OFFICIAL NOTICE OF DECISION

CITY OF ALBUQUERQUE
PLANNING DEPARTMENT
DEVELOPMENT REVIEW BOARD

Project# 1009363

13DRB-70657 MINOR – EXTENSION OF PRELIMINARY PLAT APPROVAL

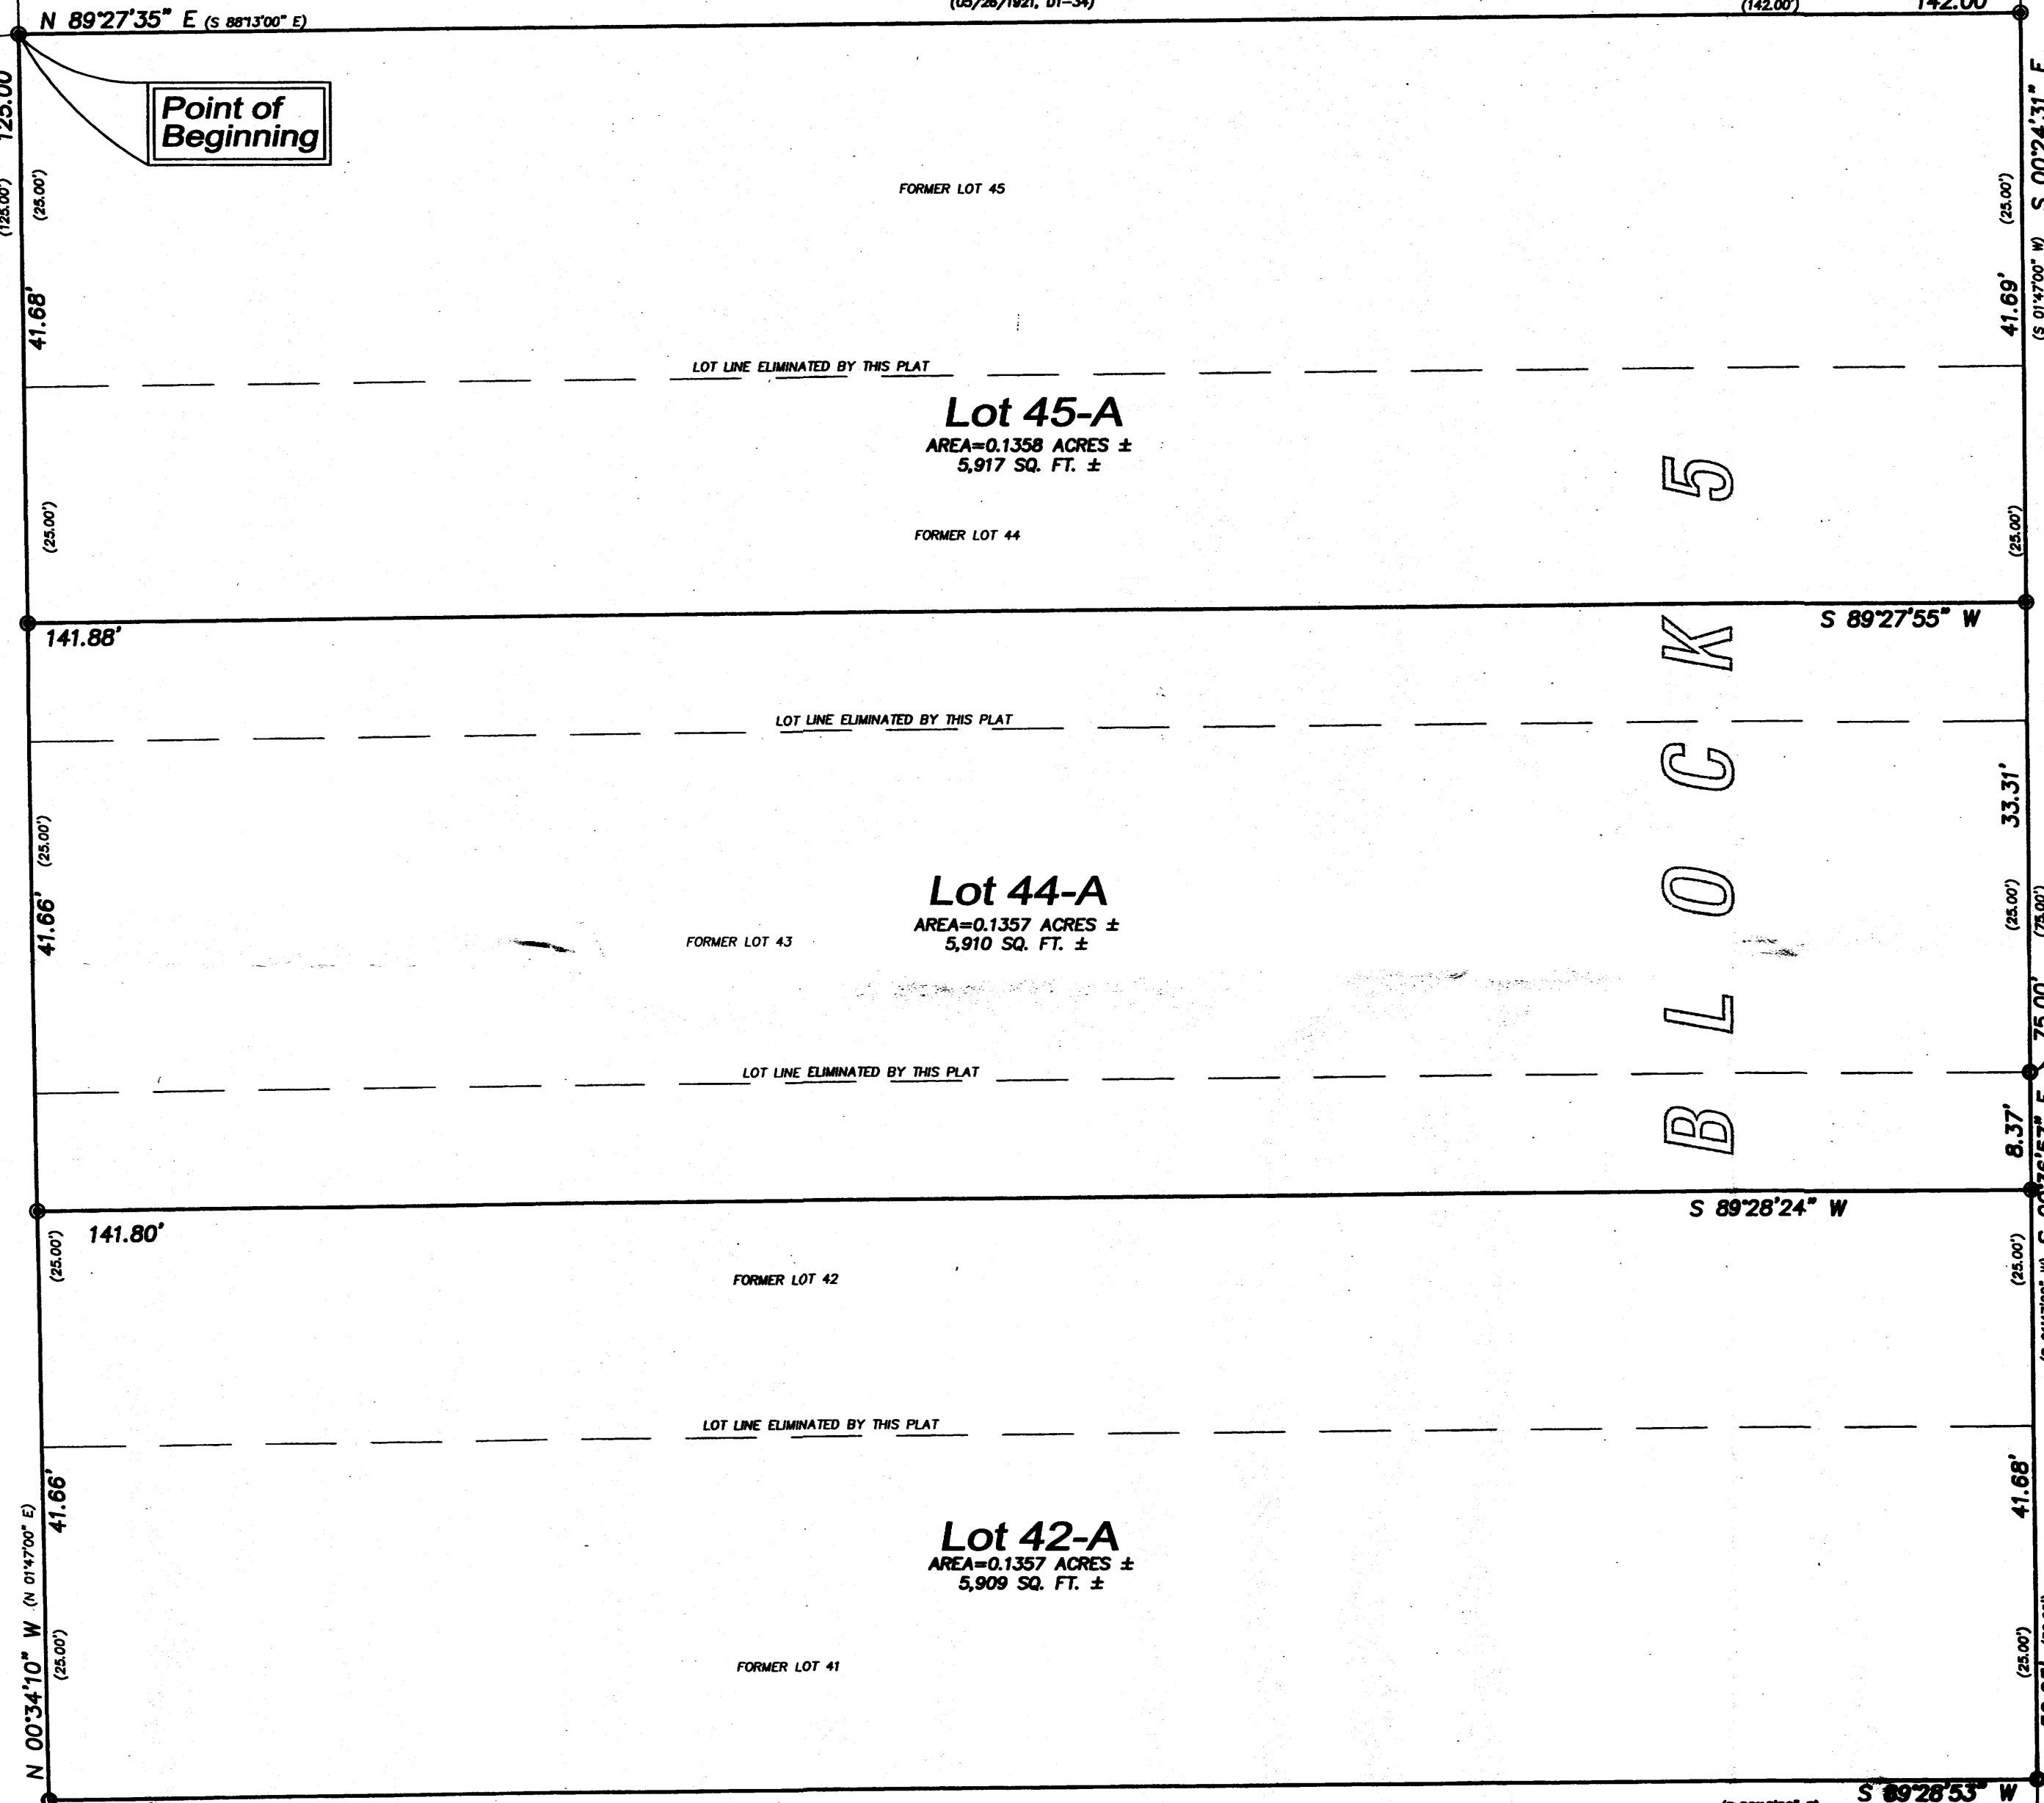
Provide proof of completion of required sidewalk.
